MODIFICATION REQUEST:

***Lot 2 DP 748682
132-138 Killeaton Street, St Ives***

***MP10_0057 MOD 4 – Modification to Amend
RLs and Rooftop Areas***

Director-General's
Environmental Assessment Report
Section 75W of the
Environmental Planning and Assessment Act 1979

PRINT ROOM - FOR UTM 10 BE RULED - DA-23 STAGE-1 LEVEL 3 PLAN.DWG - 11/12/2011 - 15:29

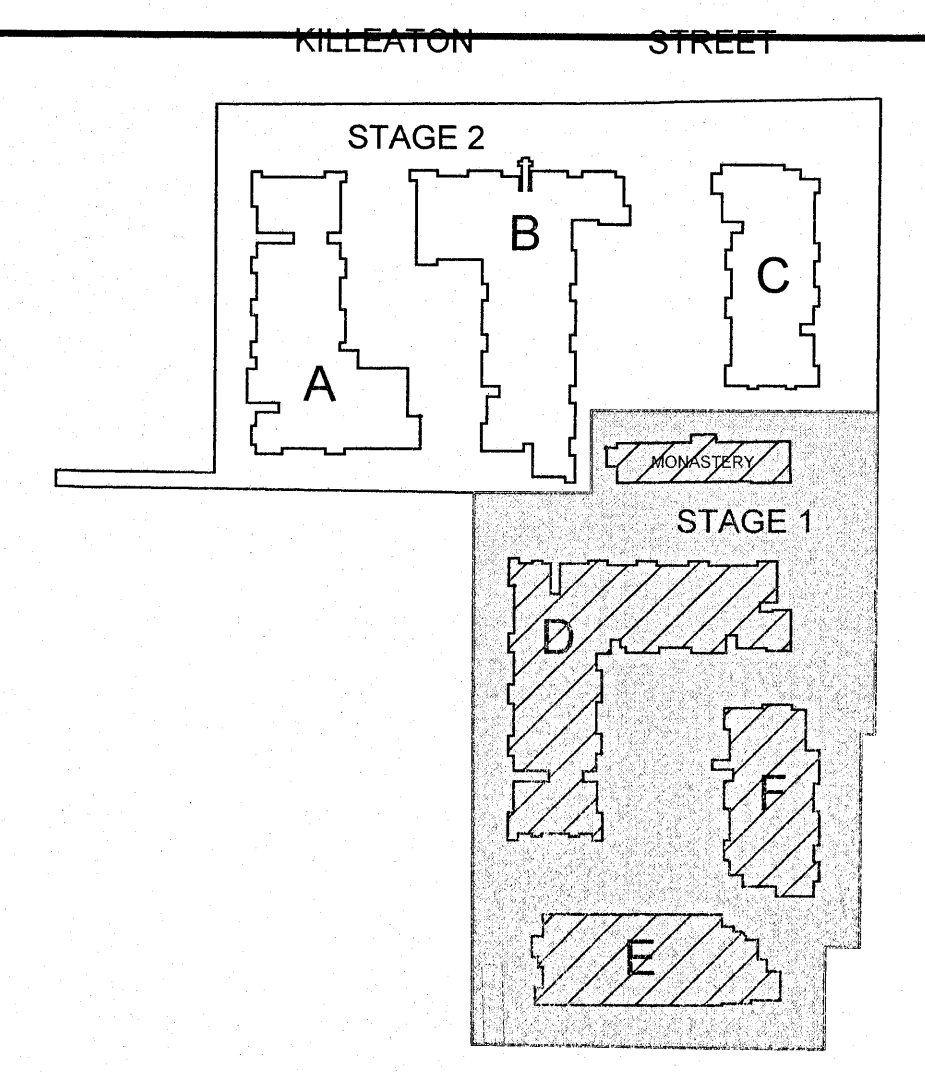
5.1.3 Pergolas

The proposed addition of pergolas for eleven top floor apartments reflects the intent of the Residential Flat Design Code as it enhances the residential amenity for future occupants by providing shading and glare control for these private open space areas. The pergolas are considered to be minor light-weight additions that are consistent with the approved ceiling heights, will match the approved colours and materials of the development, and are in keeping with the
